Subject: Draft Response - RE: Planning Consultation on: FG/157/21/PL

**1 South Drive,
Ferring,
BN12 5QS**

FRA review

SK11 Rev. D

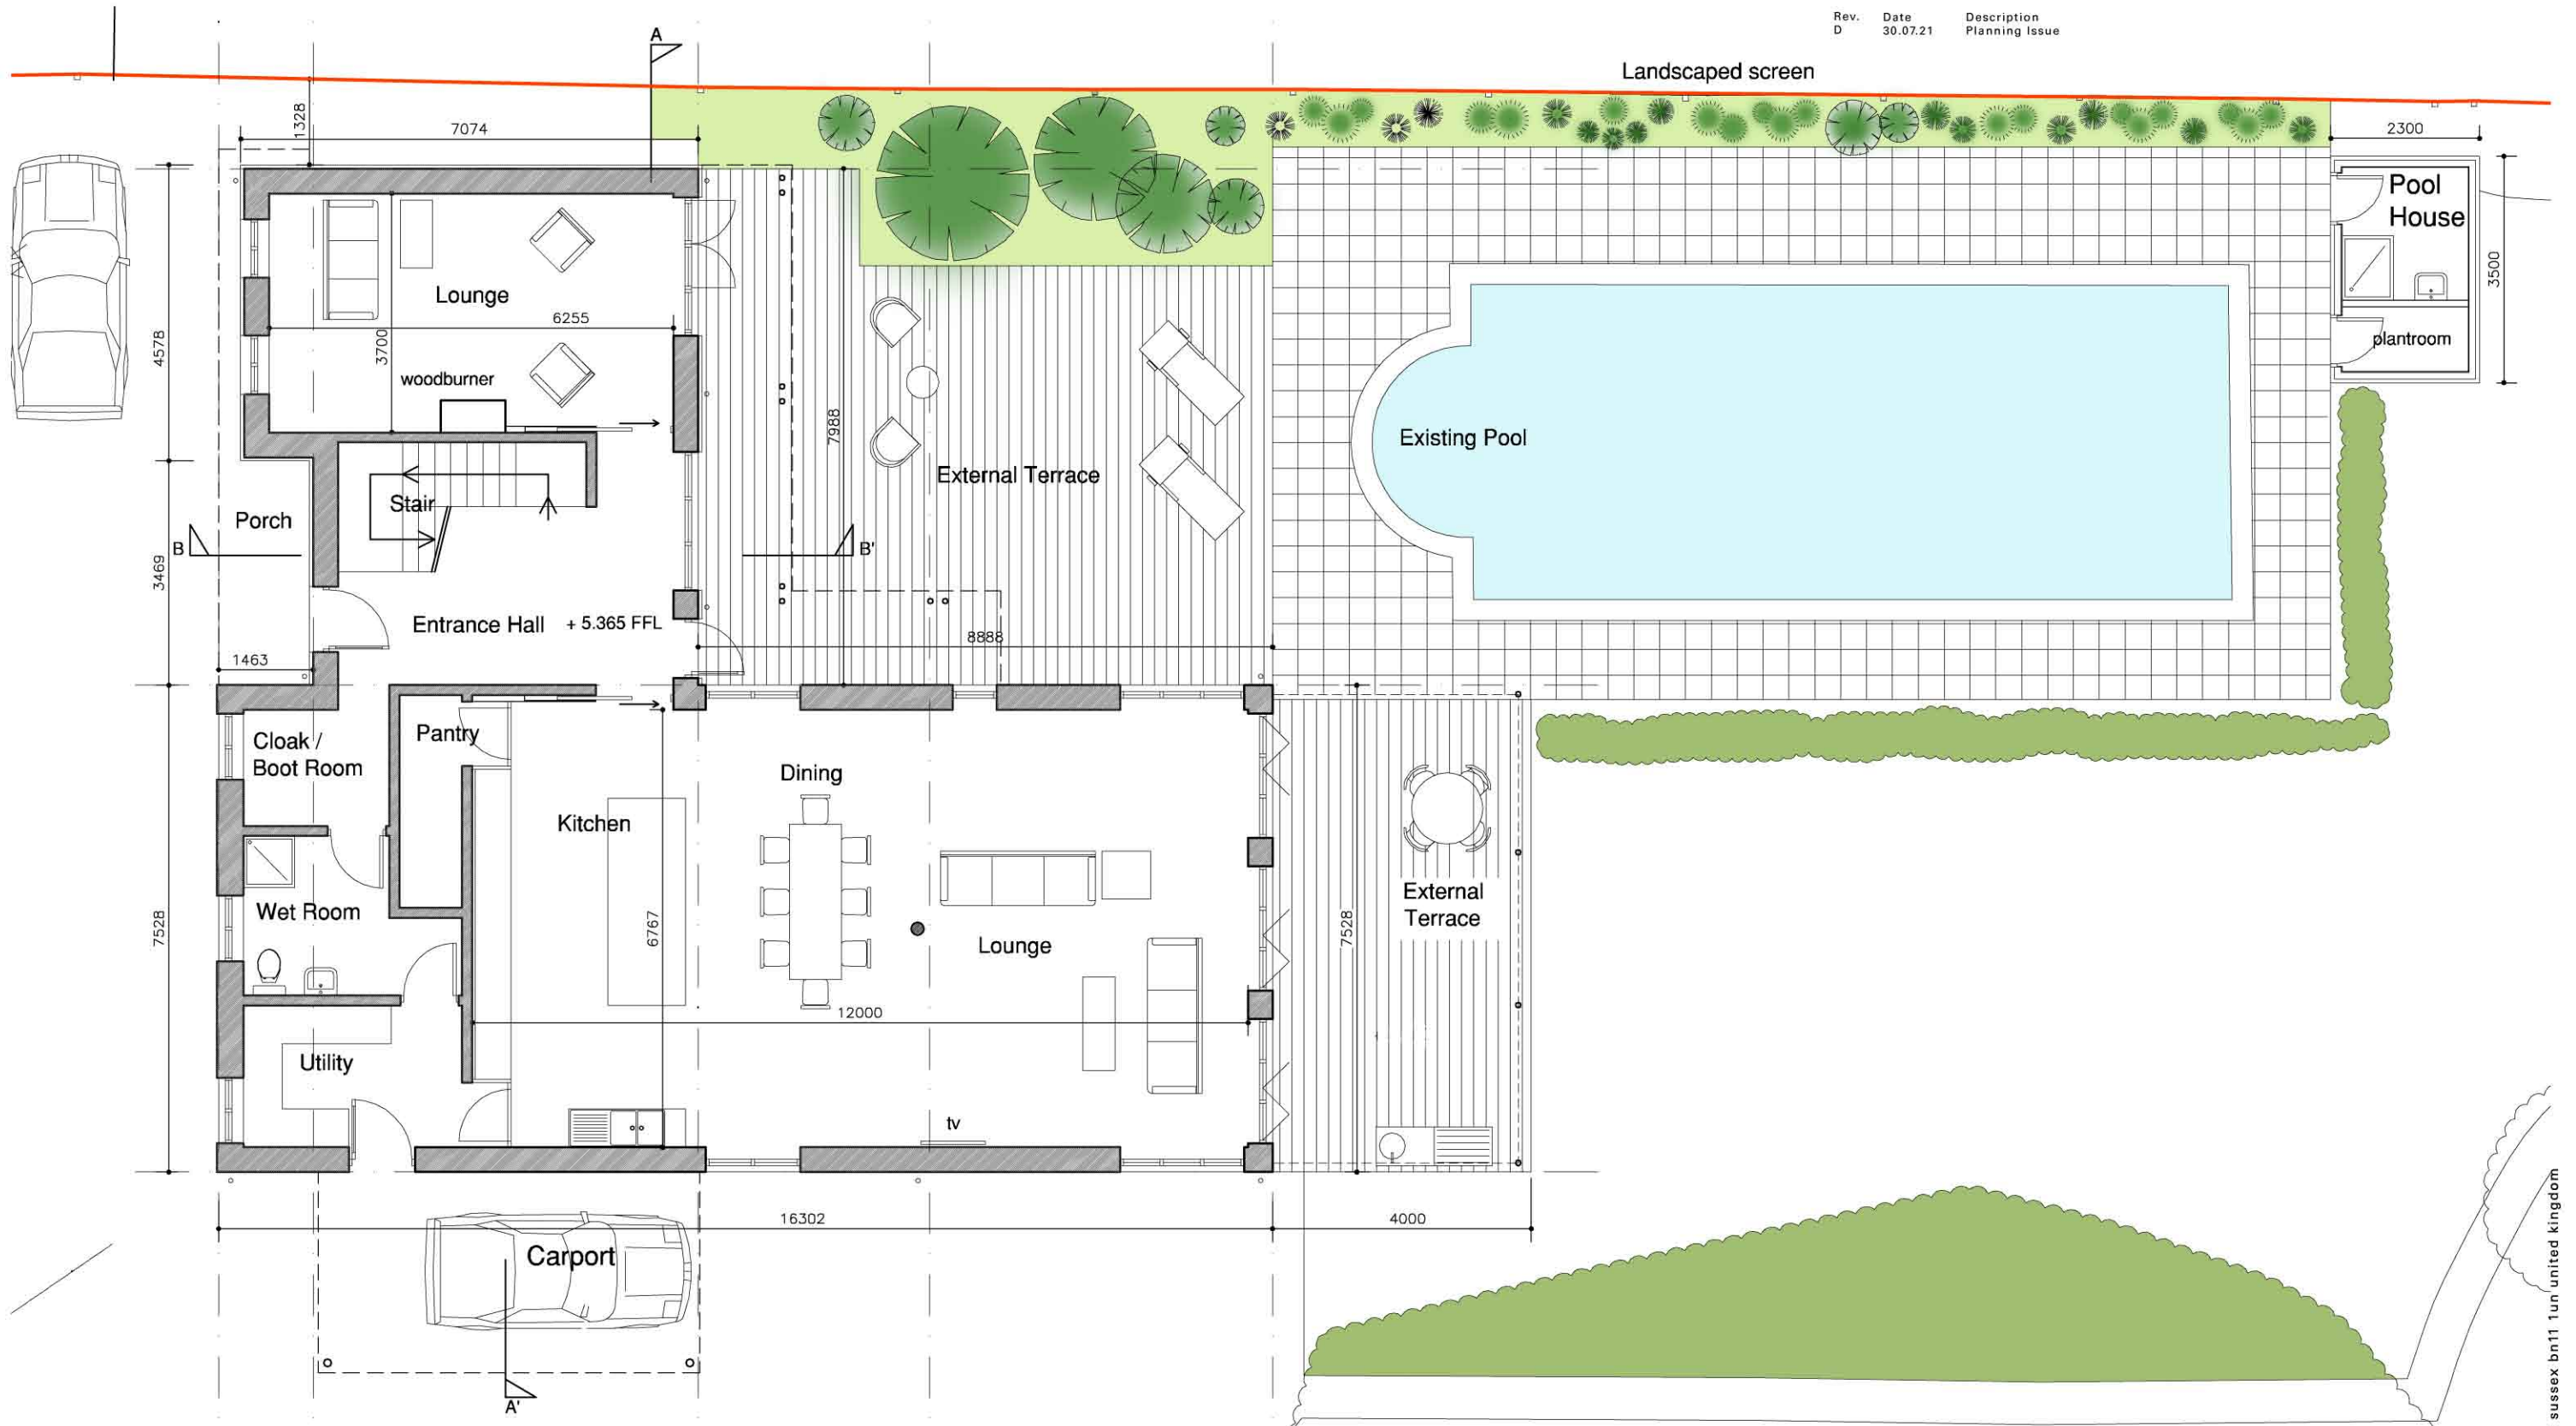
The proposal seeks to replicate the ground floor level of the existing property which has been referred to in drawing SK11 Rev.D as 5.365 AOD. However, the FRA has failed to submit modelling results so I am unsure as to whether this is above the 1 in 200 (0.5% AEP) 2115 flood level. This information can be obtained from the Environment Agency by following the "Guidance for Flood Risk Assessments" – [Flood risk assessments if you're applying for planning permission - GOV.UK \(www.gov.uk\)](#)

Interrogating LIDAR mapping I am able to confirm that the lowest portion of the site is located just south of the existing property. It would be prudent to consider landscaping that is sympathetic to the finished floor levels to minimise internal flooding, should flooding occur.
